February 8, 2023

Re: Project No. HA-3339-RAJ/JKB  
FID No. 921084  
Springs of Ballentine (The)  
New 50 Bed Assisted Living Facility  
Fuquay Varina (Harnett)

The architectural portion of revised construction documents dated January 20, 2023 (received January 25, 2023) for the referenced project has been reviewed for conformance with licensure rules for Adult Care Homes (10A NCAC Chapter 13 Subchapter F). The architectural portion of the drawings are approved provided we receive satisfactory written responses to the following comments:

## LIFE SAFETY PLAN

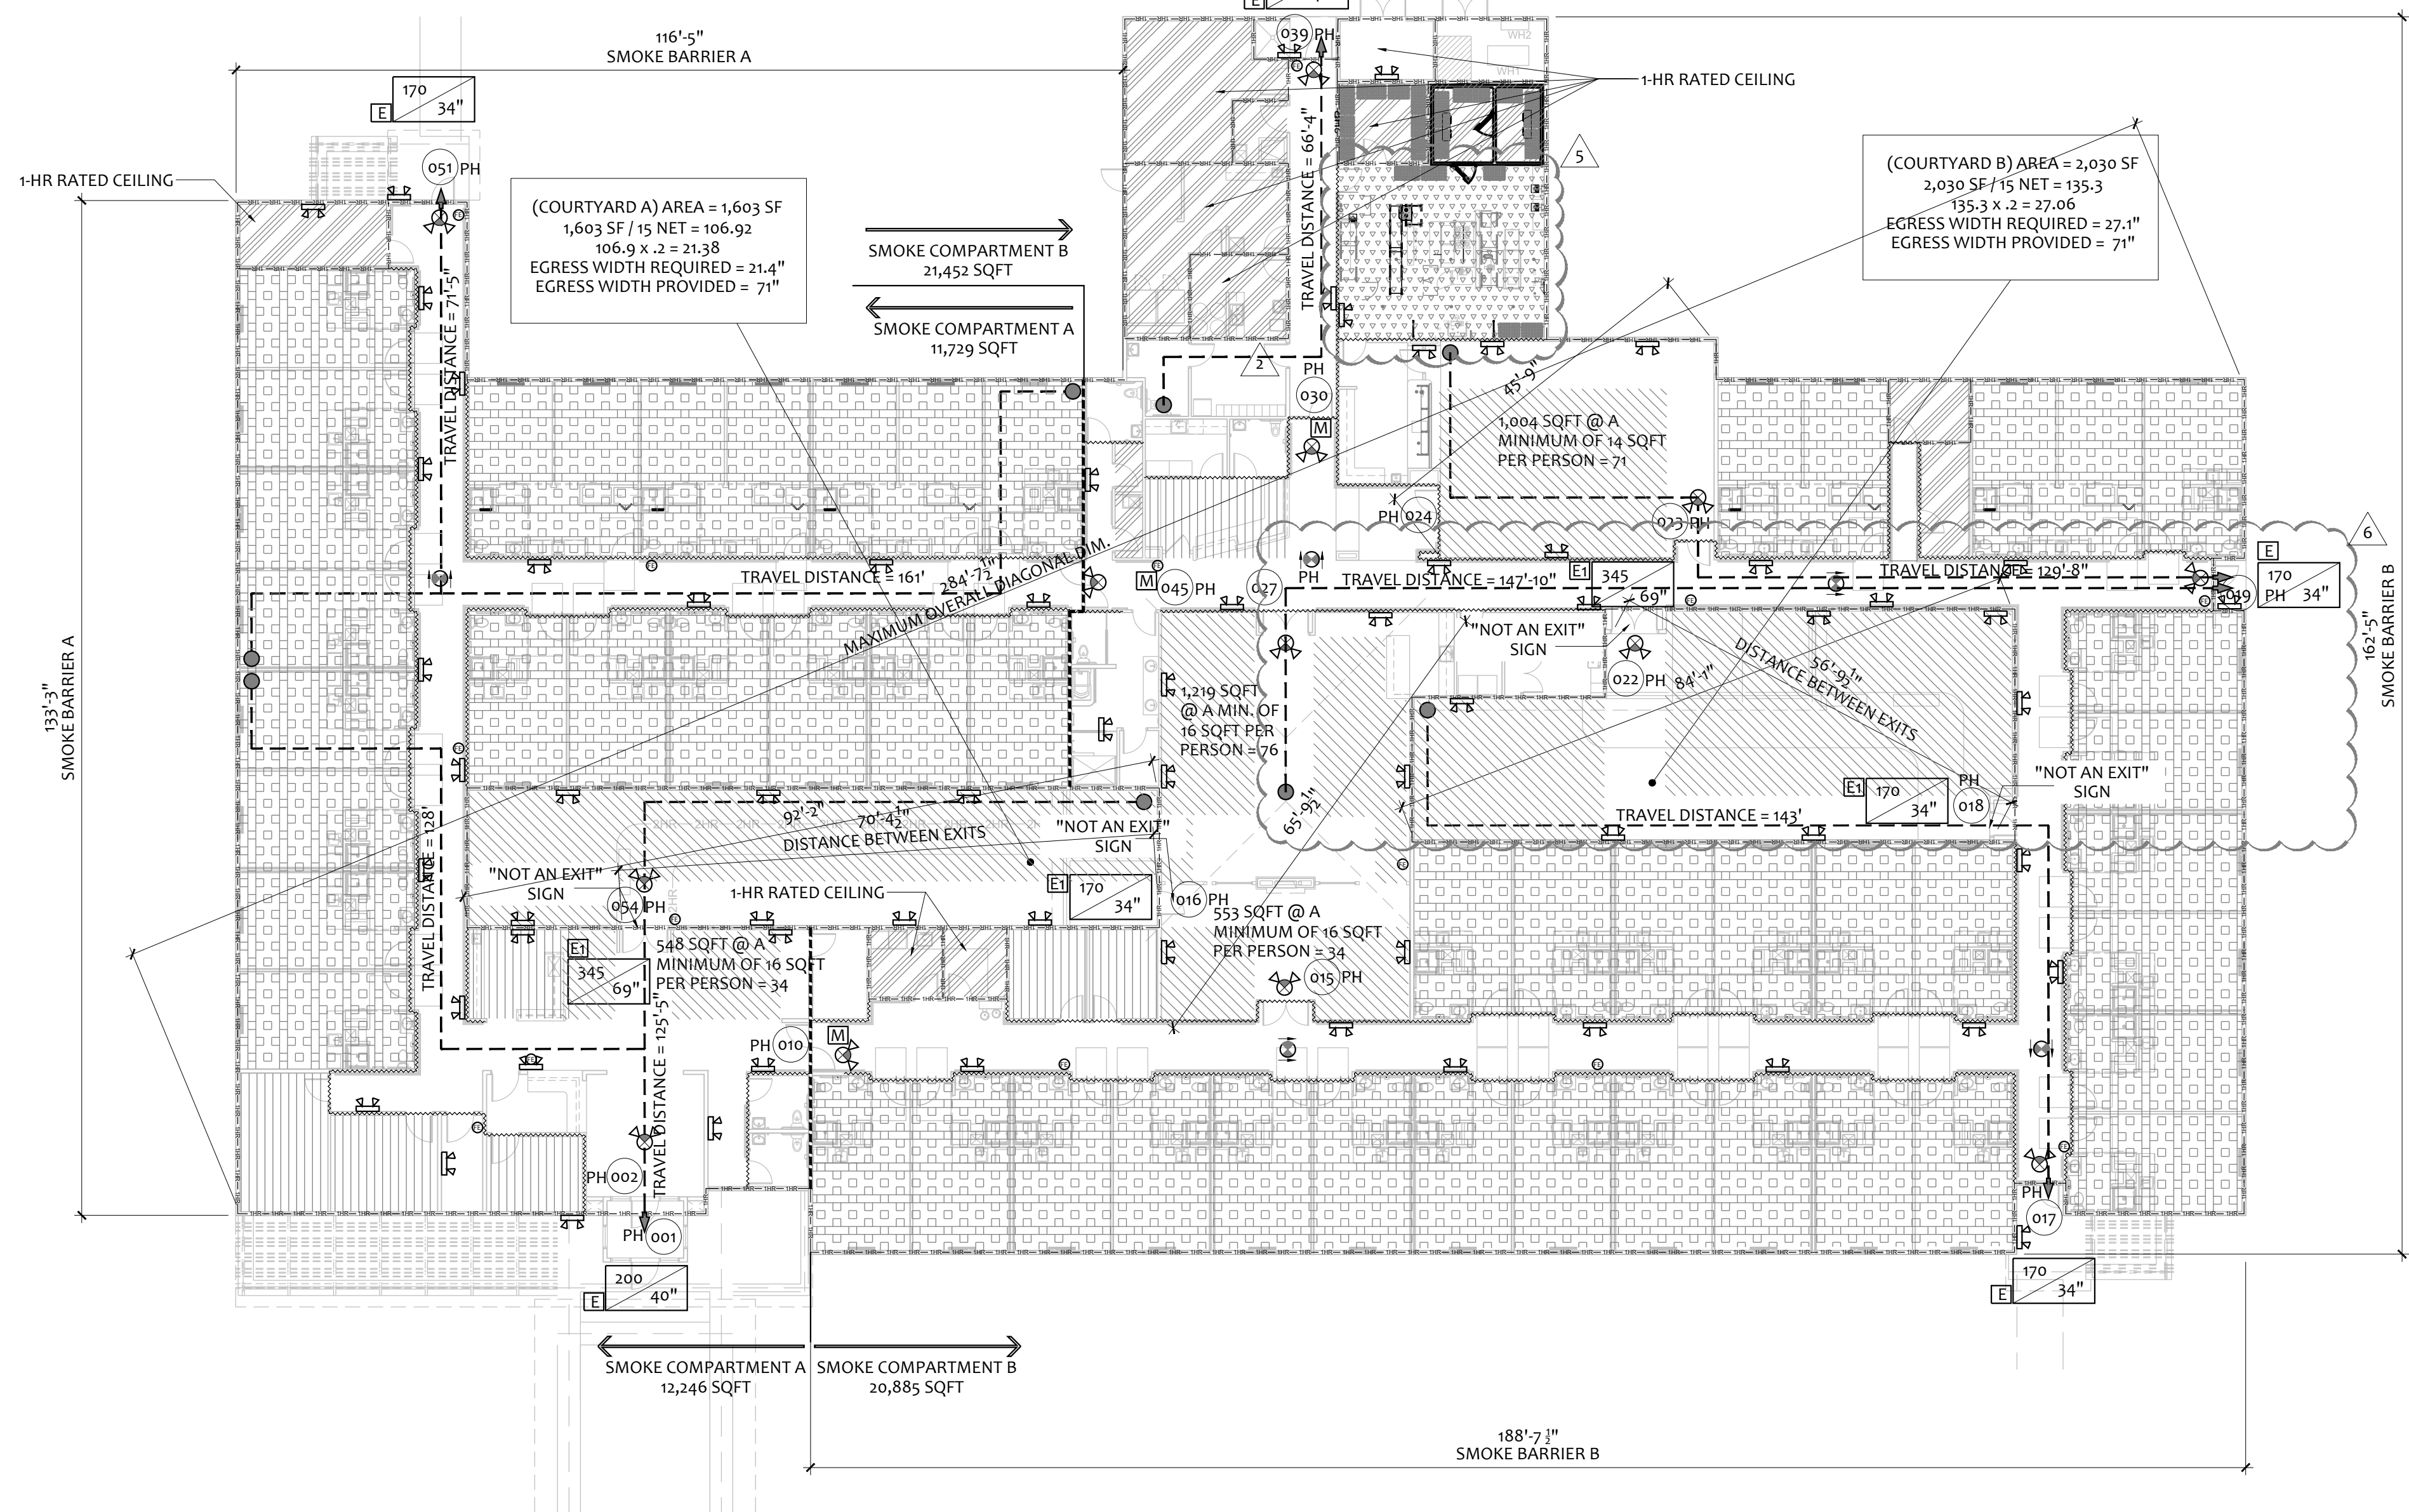
1. Show the location of the Soiled Utility that is equipped for cleaning and sanitizing of bedpans. [10A NCAC 13F .0305 (J)]
2. Storage Room 170 is more than 100 square feet and must be enclosed in a 1 hour rated wall. Revise the Life Safety Plan A002 to show this rating. [North Carolina State Building Code (NCSBC) Table 509]

**A201**  
 OVERALL FLOOR PLAN

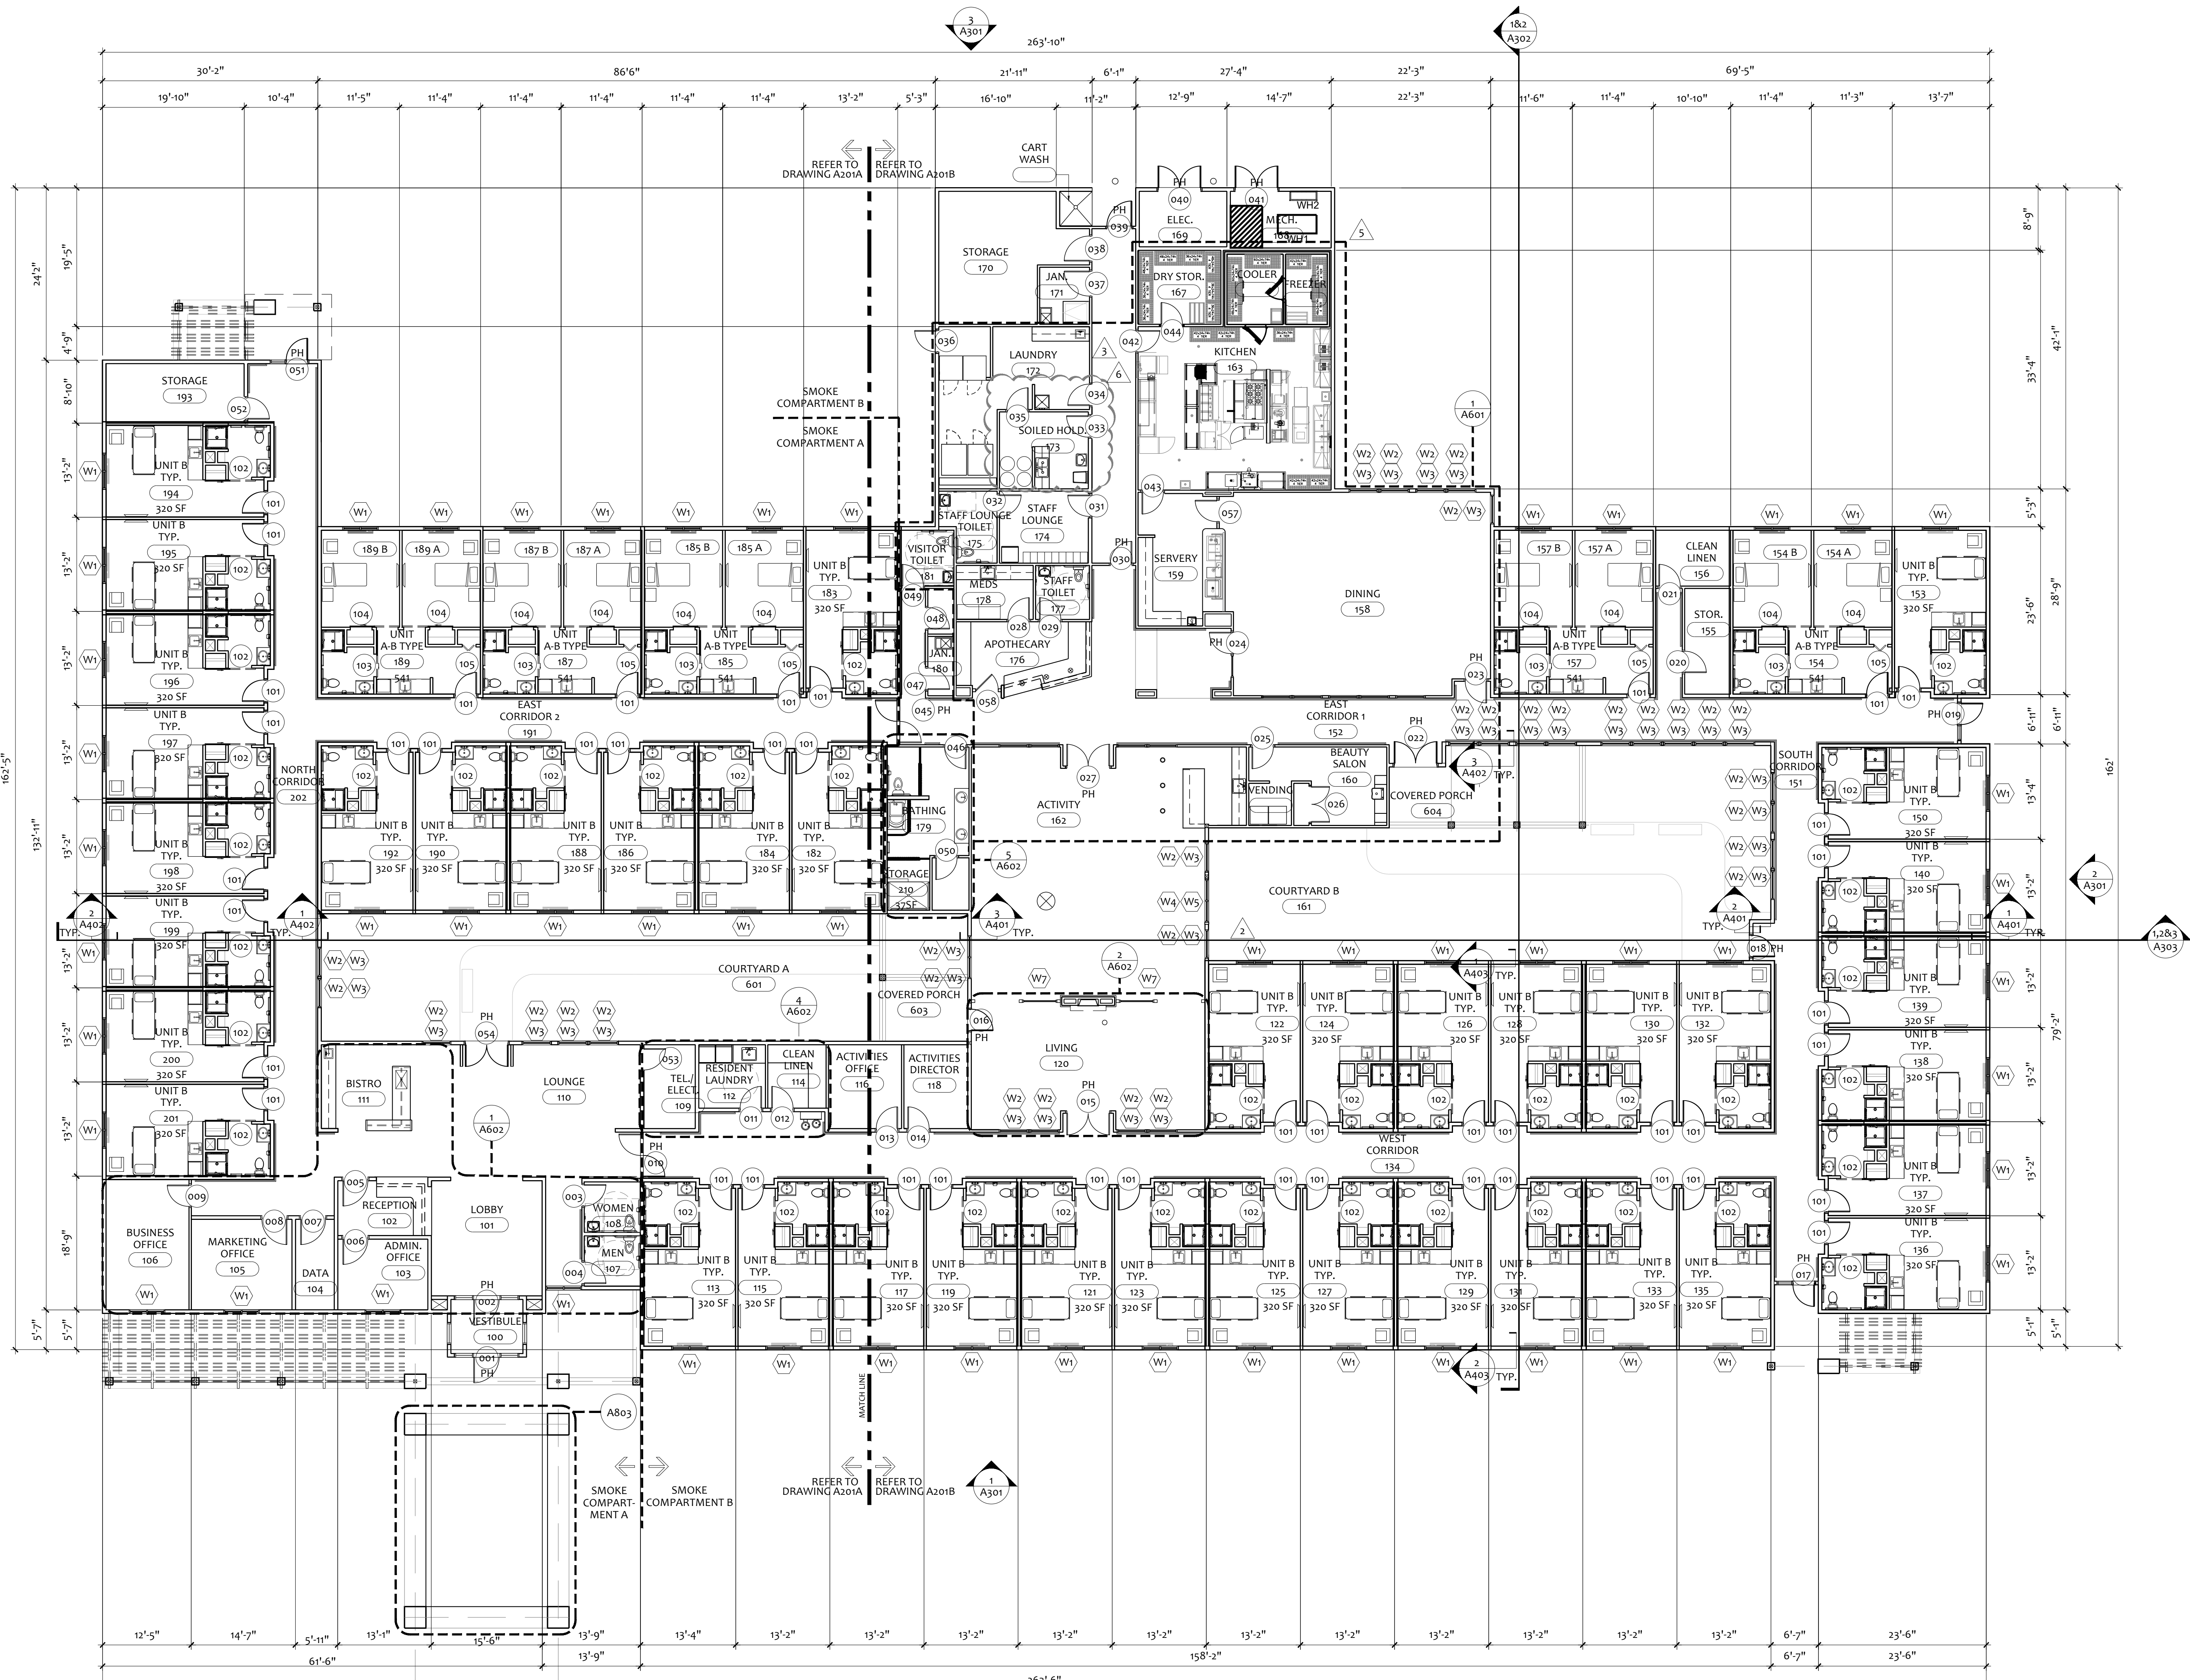
14. Reference Sheets FA102 and A201; provide a pull station within 5 feet of the exit door #017. [10A NCAC 13F .0307(c)(1)]
15. Provide heat detectors in the laundry rooms 112 and 172. [10A NCAC 13F .0307(c)(3)]

DRAWN	CR
CHECKED	RW
DATE	2/14/2023
SCALE	1/8"= 1'0"
JOB NO.	-
SHEET	FA-1
1 OF 3

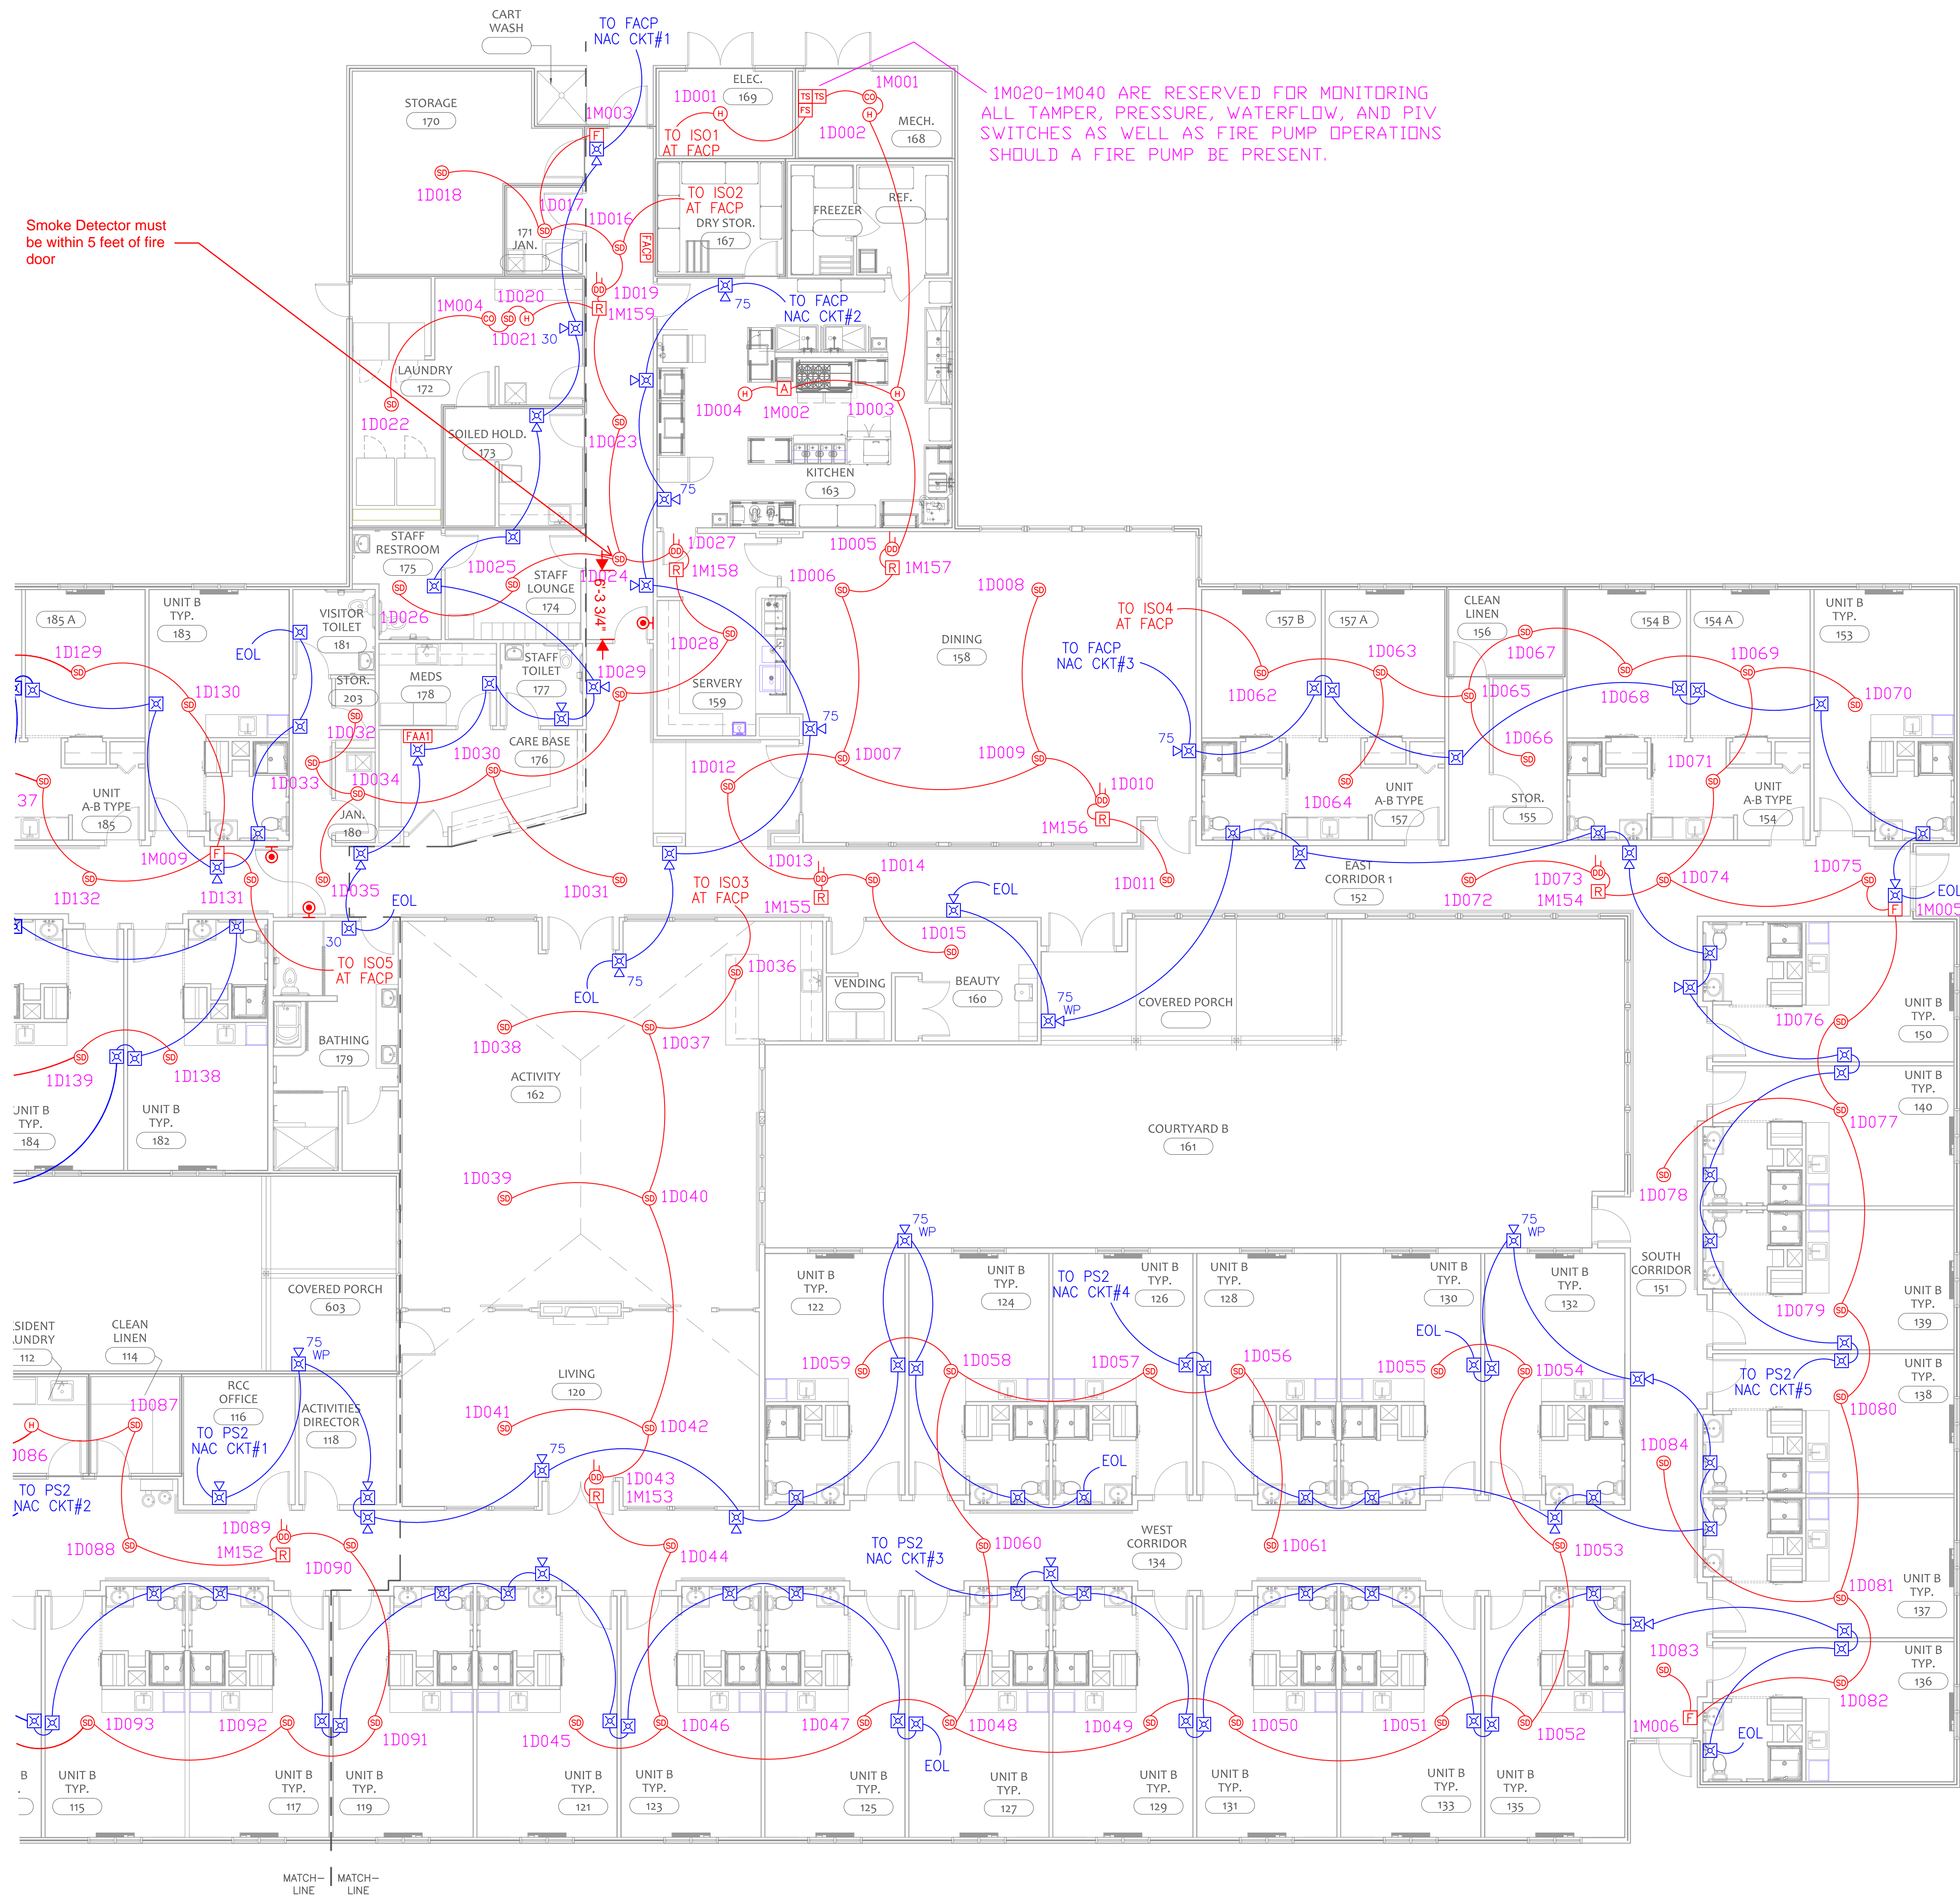
22. Reference sheets FA 101 & FA 102; Smoke detector spacing in Corridor 134 is greater than 62 feet. Please note typical spacing is 30 feet between devices.
